Application no: **3/2024/0201**

Address: **21 Abbots Croft Whalley BB7 9RR**

Proposal: **Proposed single-storey extensions to front, side and rear.**

site plan

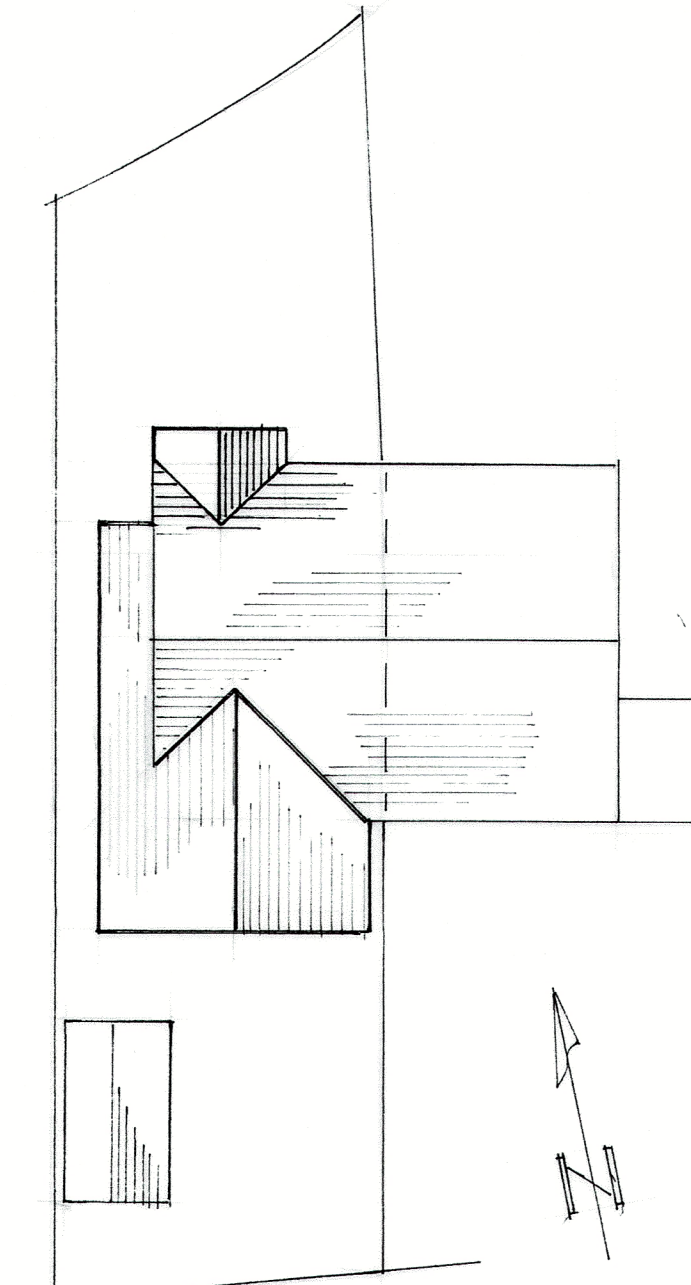
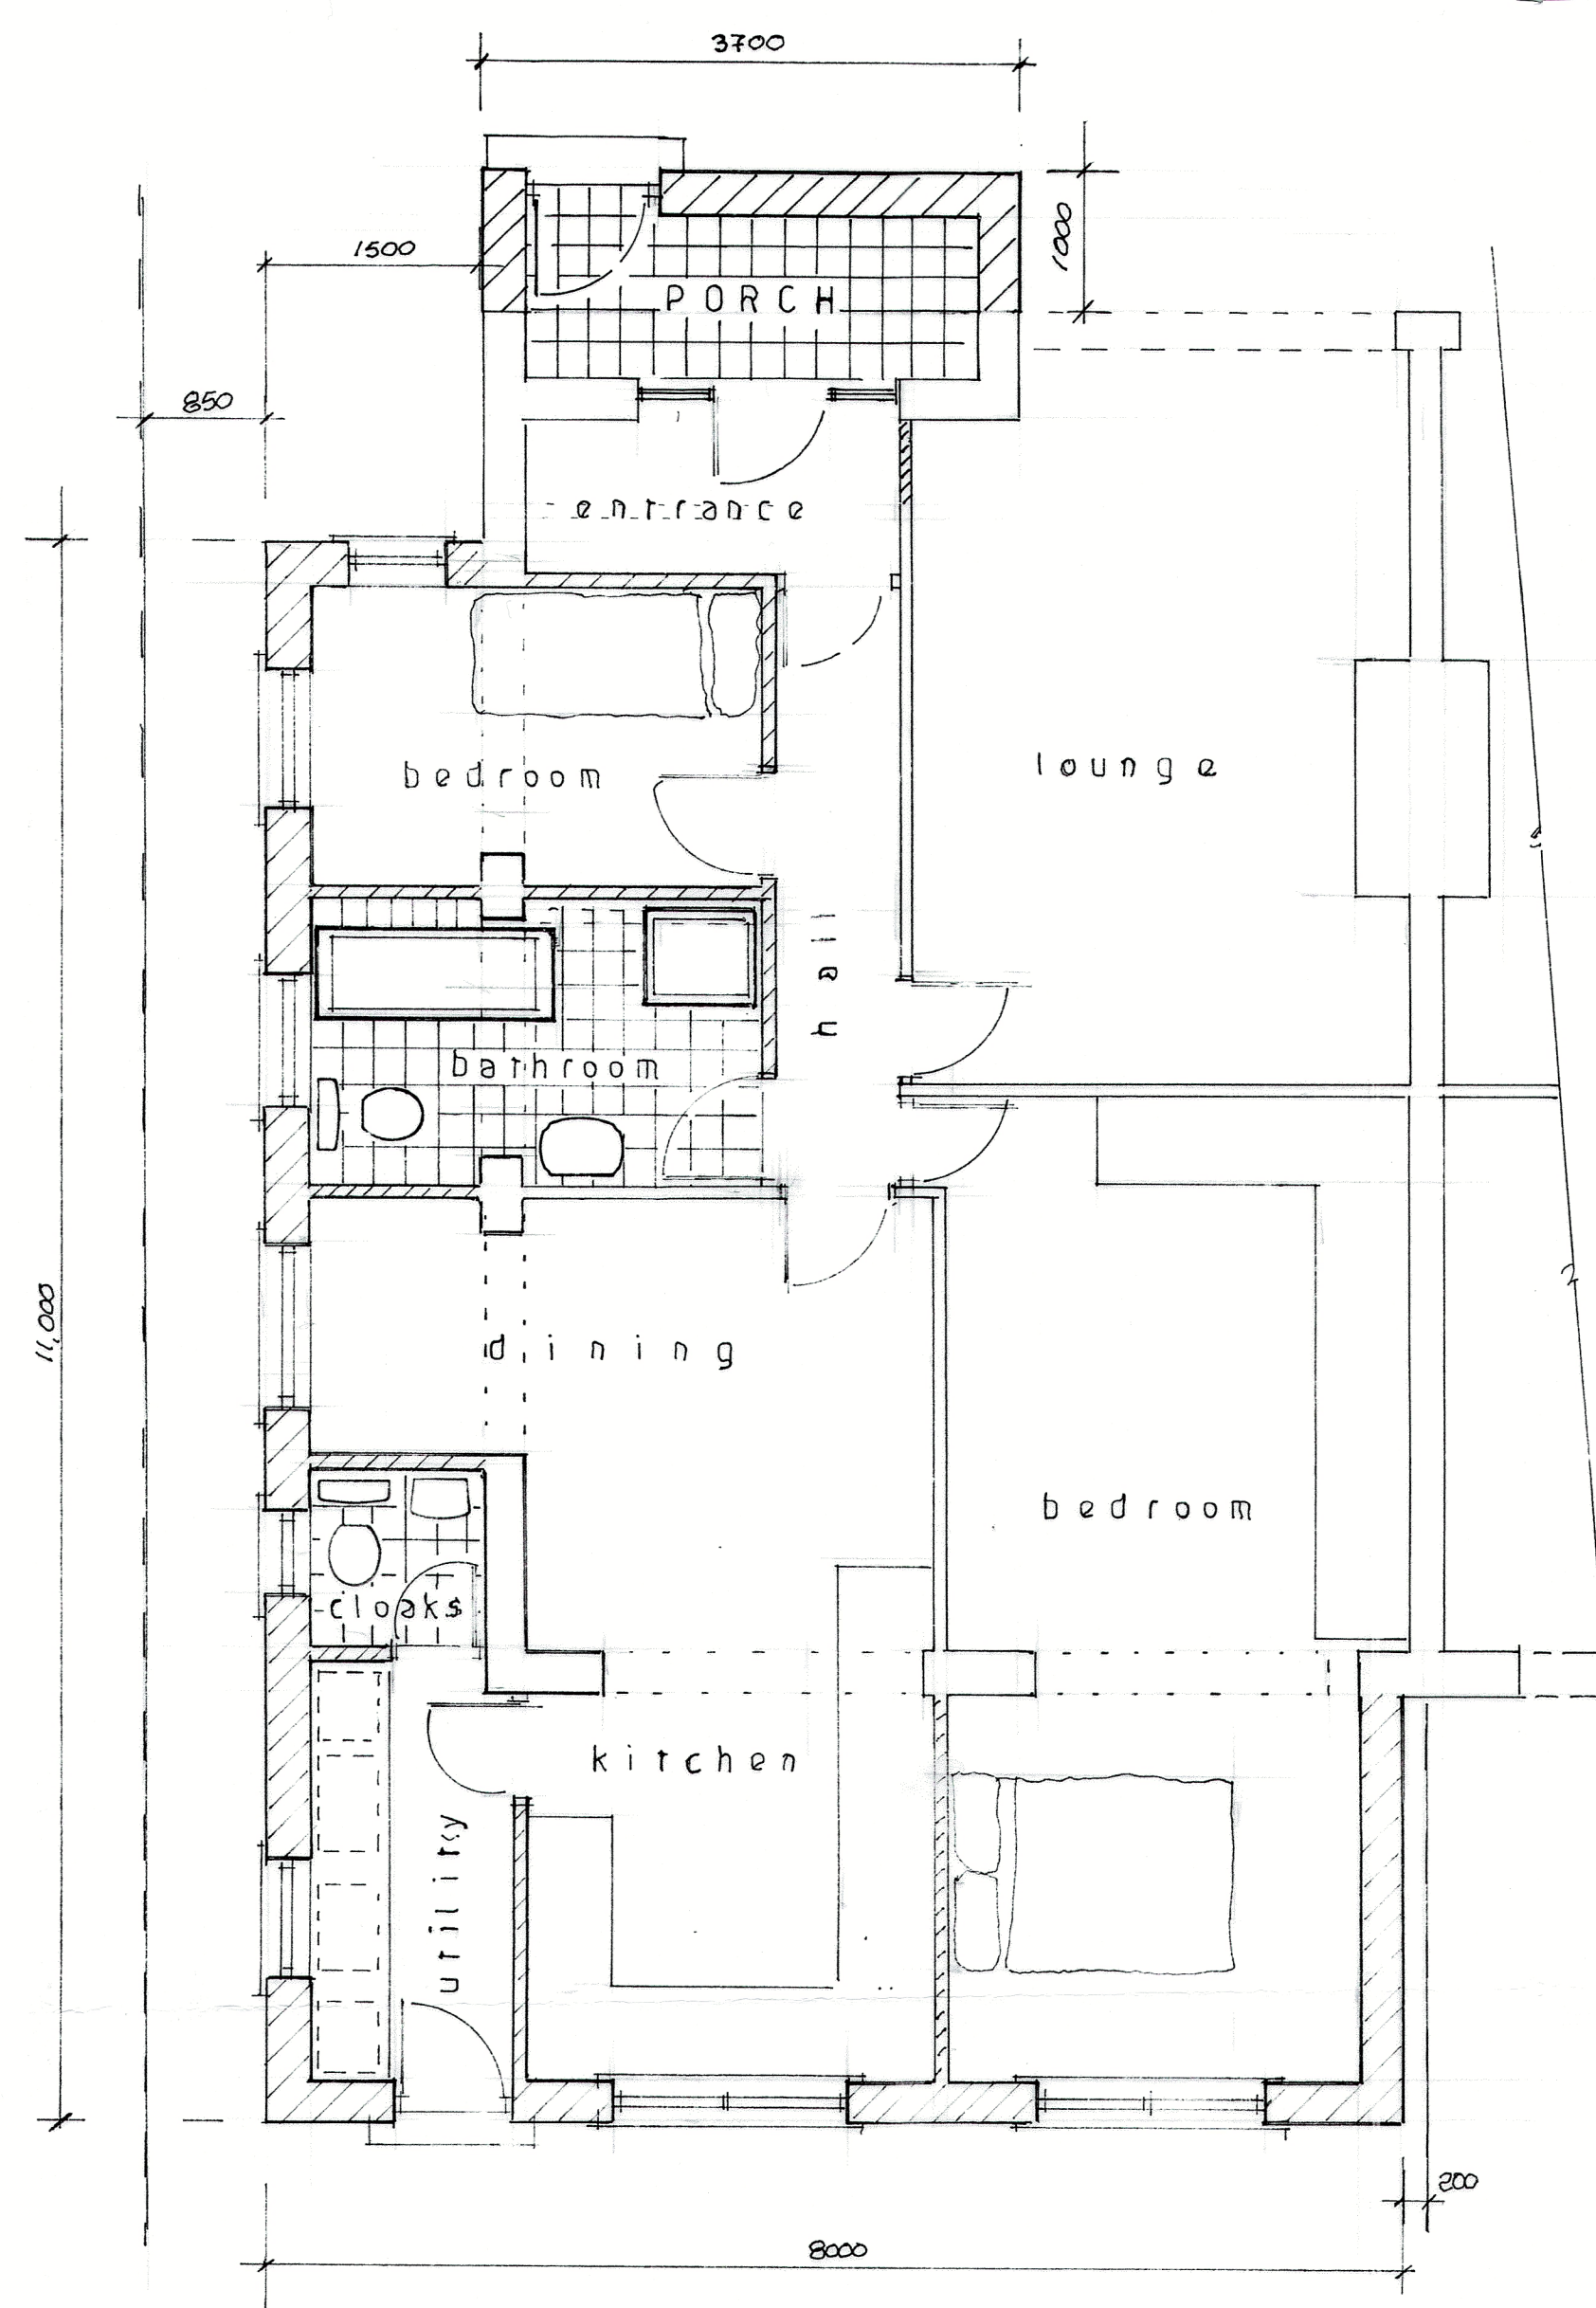
As part of the proposal the parking arrangements at the site will change, with the two existing car parking spaces being unable to be provided in tandem following the proposed side extension. Instead, as shown on SJ Bialecki drawing number 6007a, two car parking spaces will be provided adjacent to each other.

However, the LHA have reviewed the proposed arrangements and are unable to accept the proposed second space which will be provided at an angle to the access. This is because the LHA are concerned that should vehicles use this space, potential conflicts may arise with the adjacent streetlight when manoeuvring in and out of the access. Therefore, the LHA advise that the dropped crossing is extended to facilitate two car parking spaces.

The LHA did advise that the dropped crossing should be extended in the previous response, but no plans have been submitted showing this. Therefore, the LHA have to imply that the Applicant is unwilling to extend the dropped crossing. Should this be the case, the LHA are happy to accept a shortfall of one car parking space at the site. This is because while the LHA do not want to encourage on-street parking, but should this occur, it will not be to the detriment of highway safety with vehicular movements still being able to occur along the adopted carriageway and on-street parking, as seen on site, is a pre-existing situation along Abbots Croft. Therefore, for these reasons the LHA have no objection to the proposal.
